Subject: Re: Inglenook P/58/19/PL

For clarification Wilbar Associates were asked to undertake an independent review of the planning application in regard to highway and transport. it was not asked to put forward any options to assist in making the application acceptable.

Refuse Vehicle
Swept Path Analysis

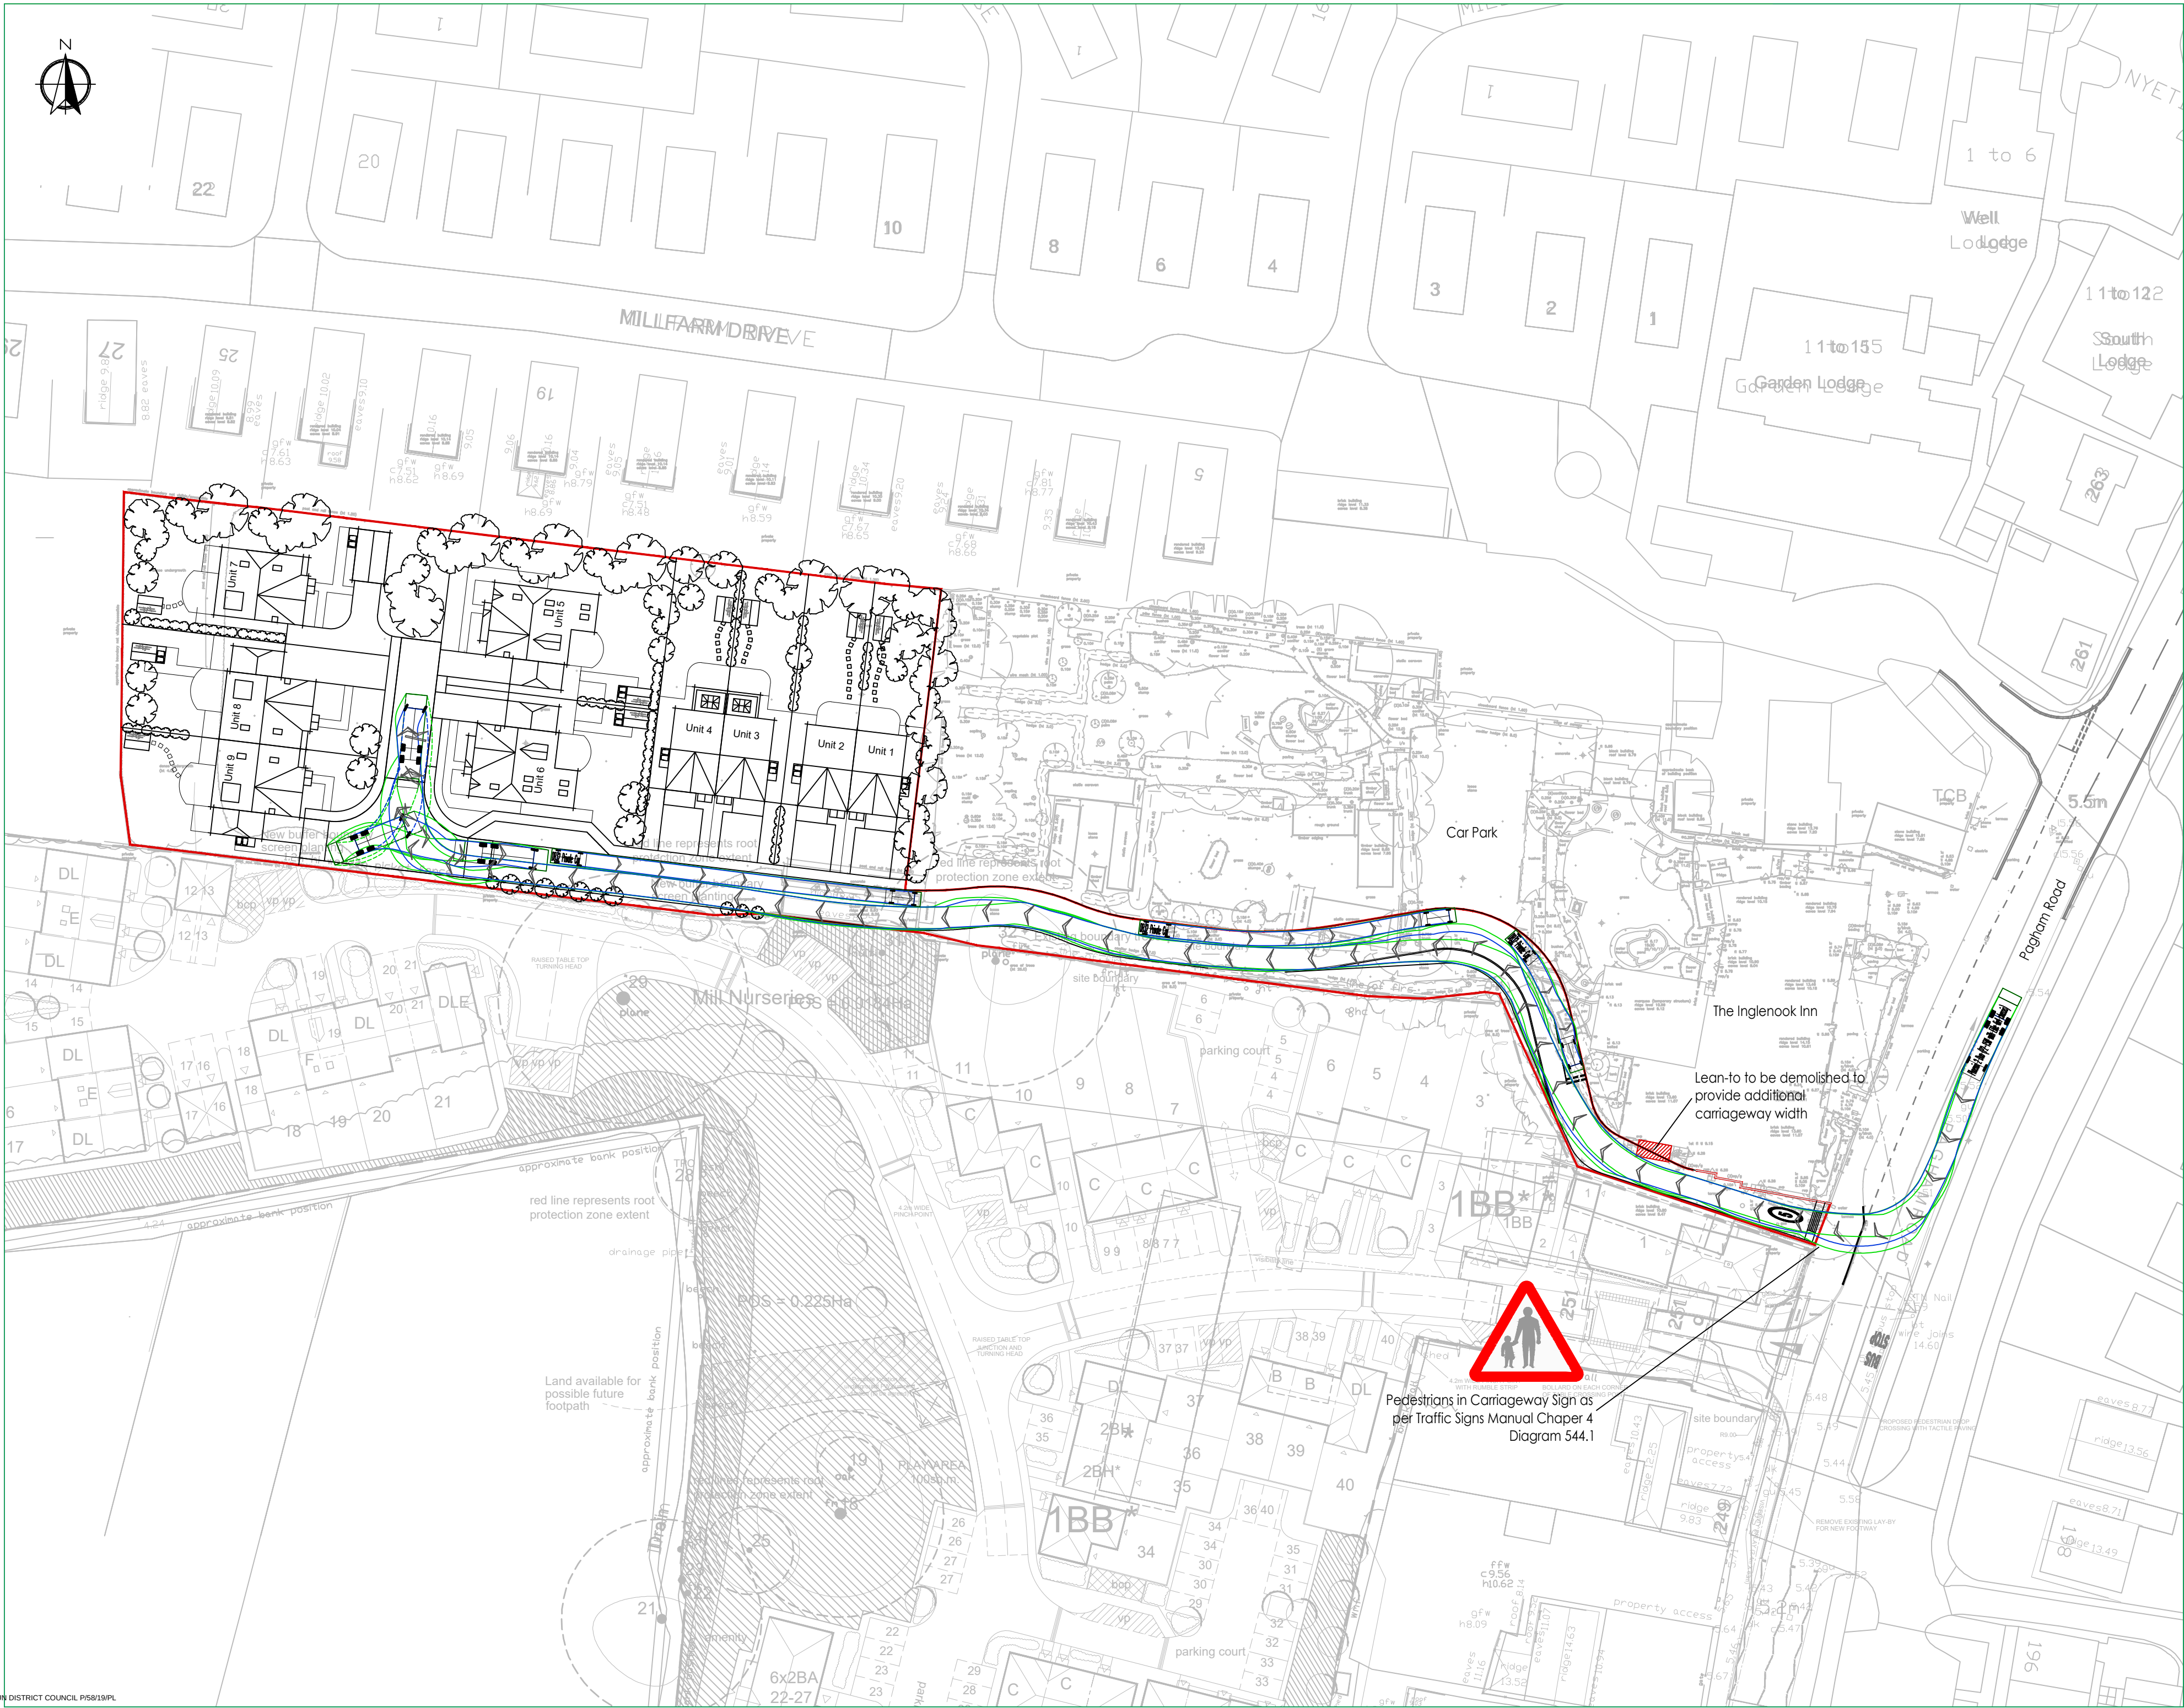
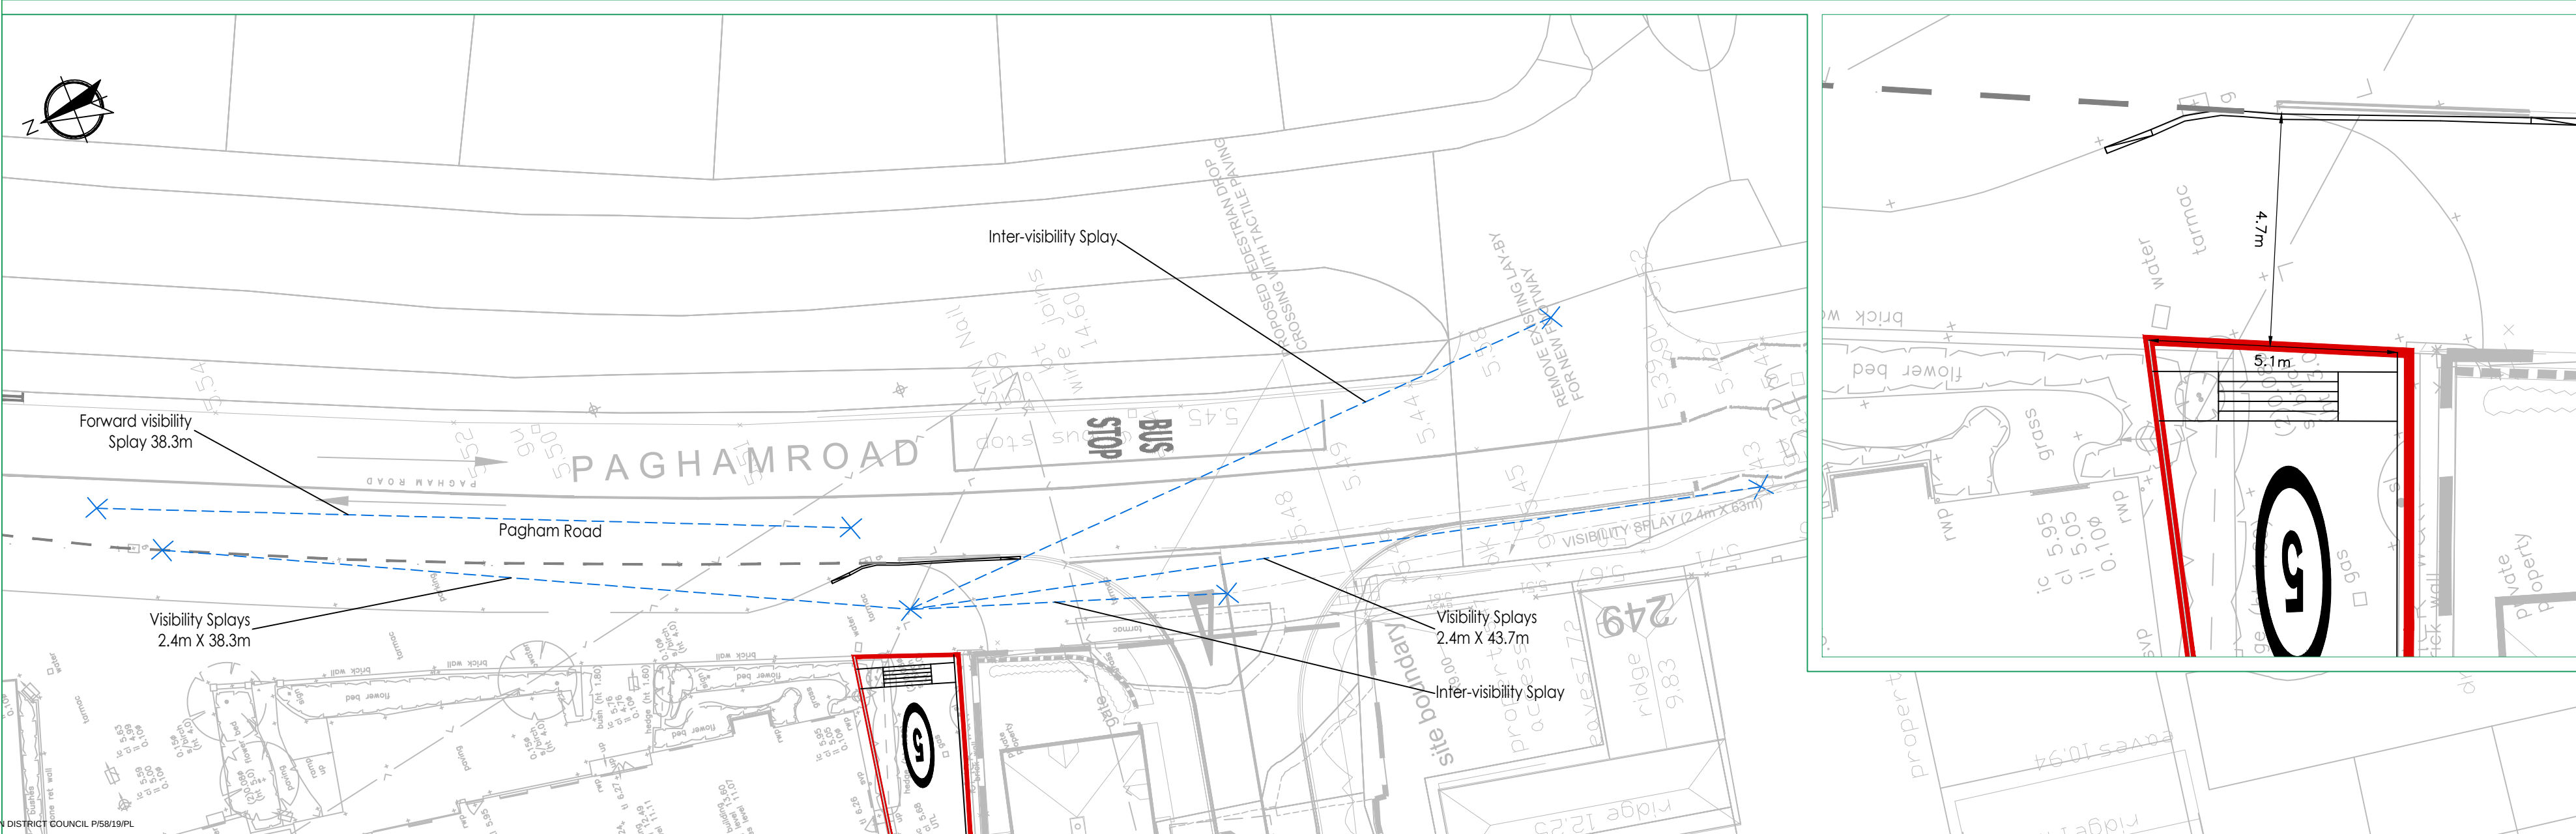
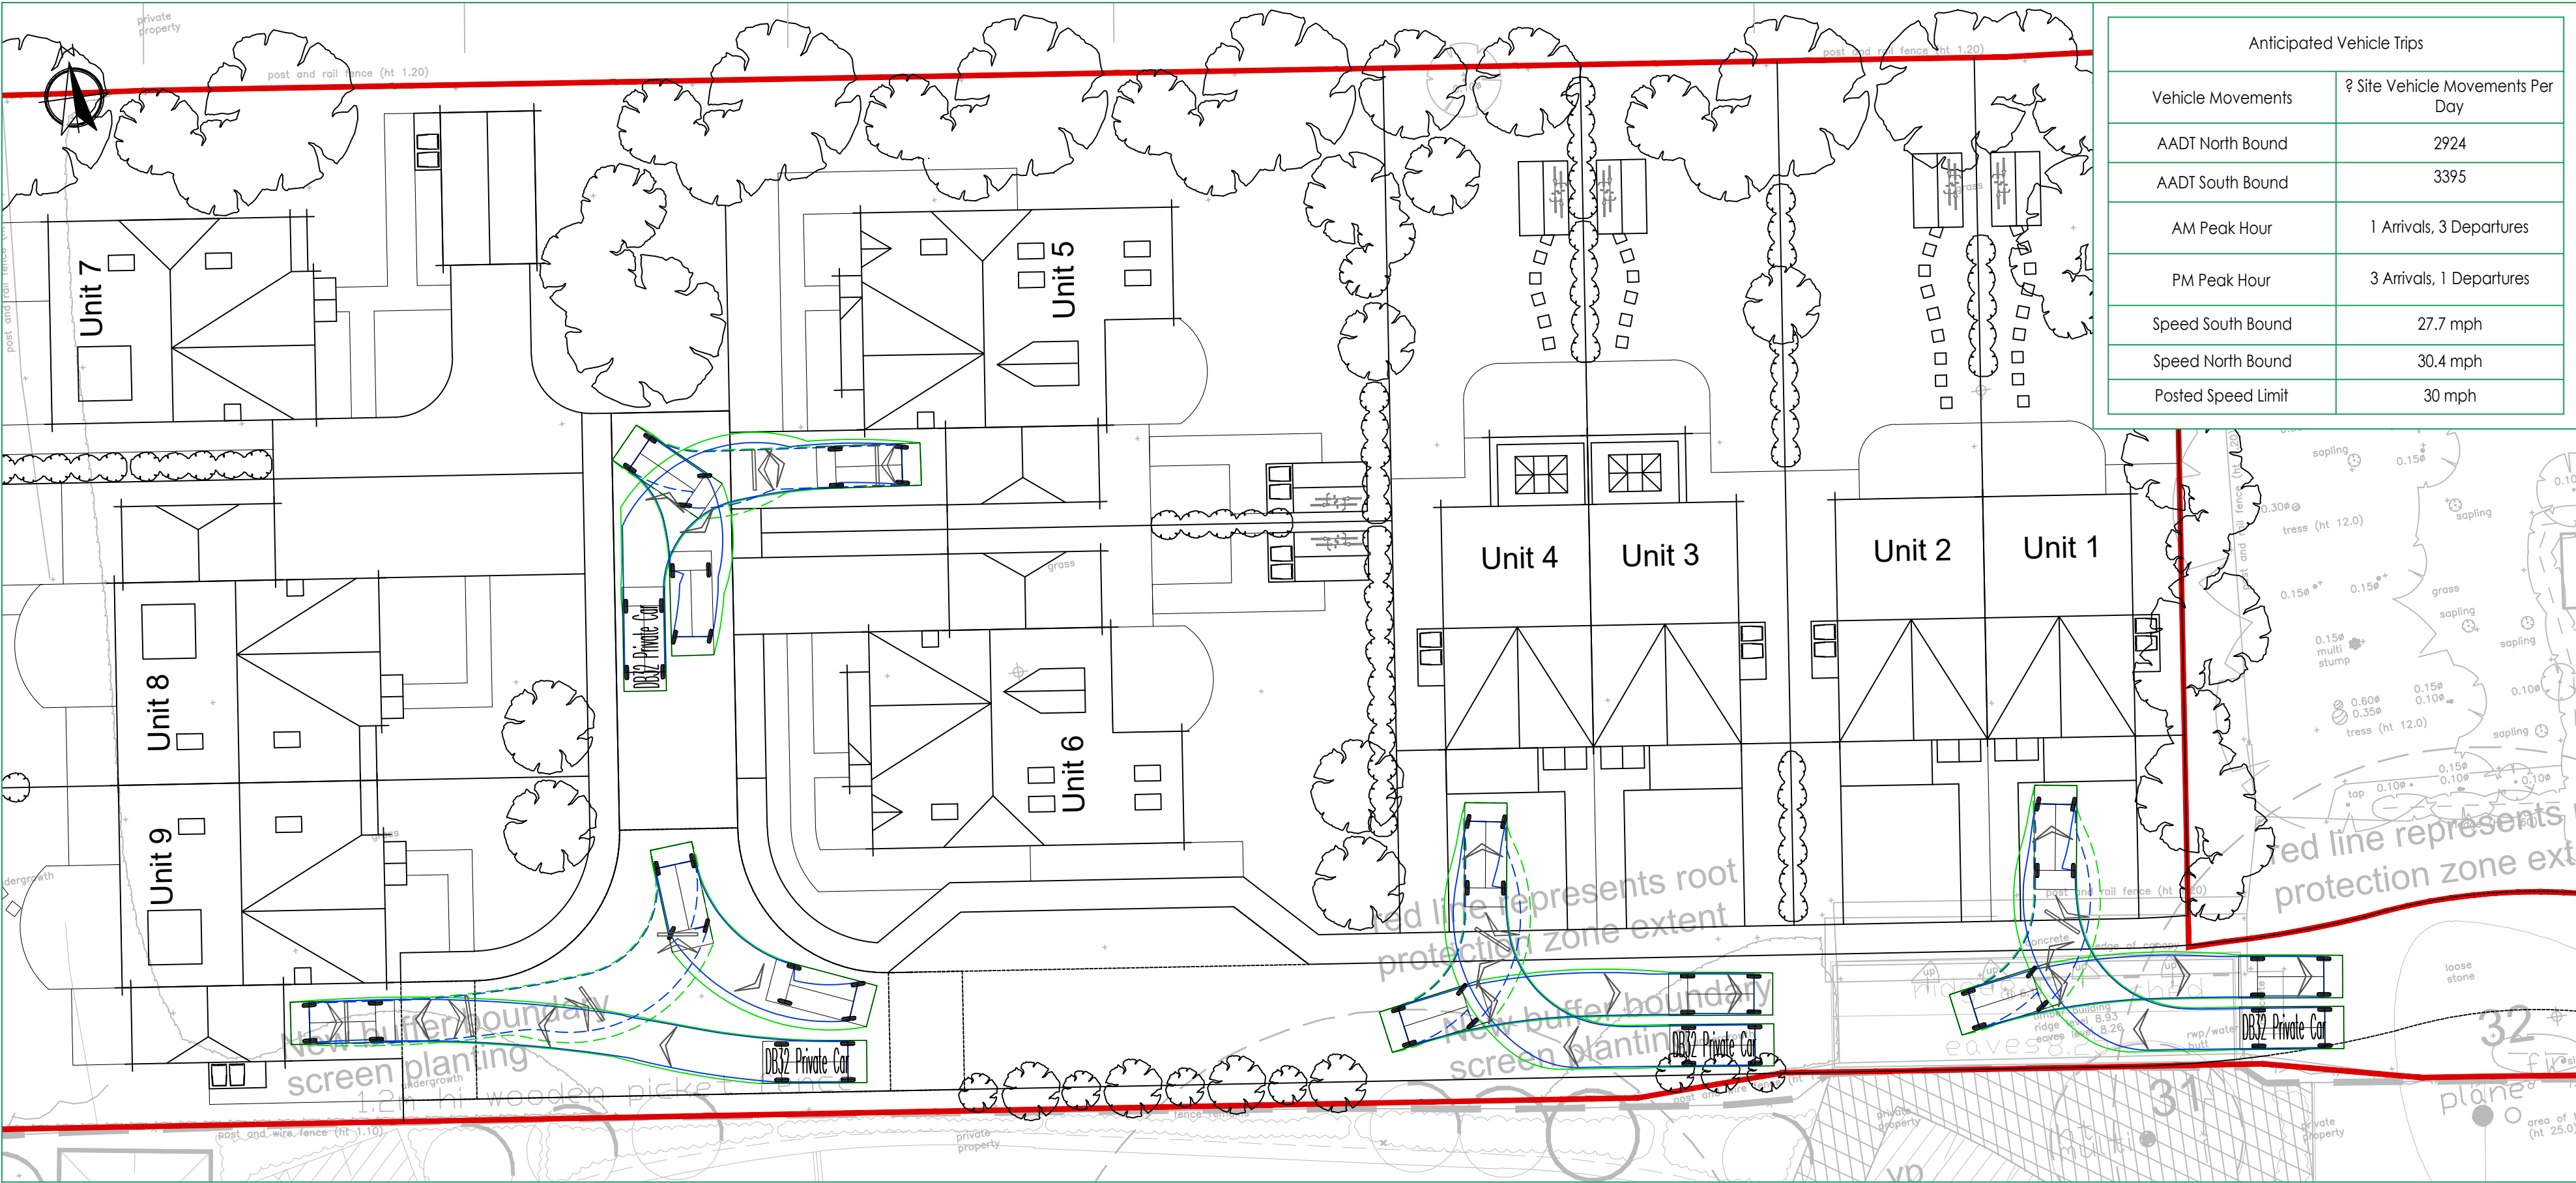
We discussed the points on the refuse vehicle entering the site turning right into from Pagham Road. The comment made was that the swept path movement didn't take account of vehicles parked and therefore the movement could not be made. A revised swept path movement from the centre of the road allowing for parked vehicles will prove if the refuse vehicle can make the turn. You also said that the street lights will be removed to allow for extra width and this would assist with manoeuvring.
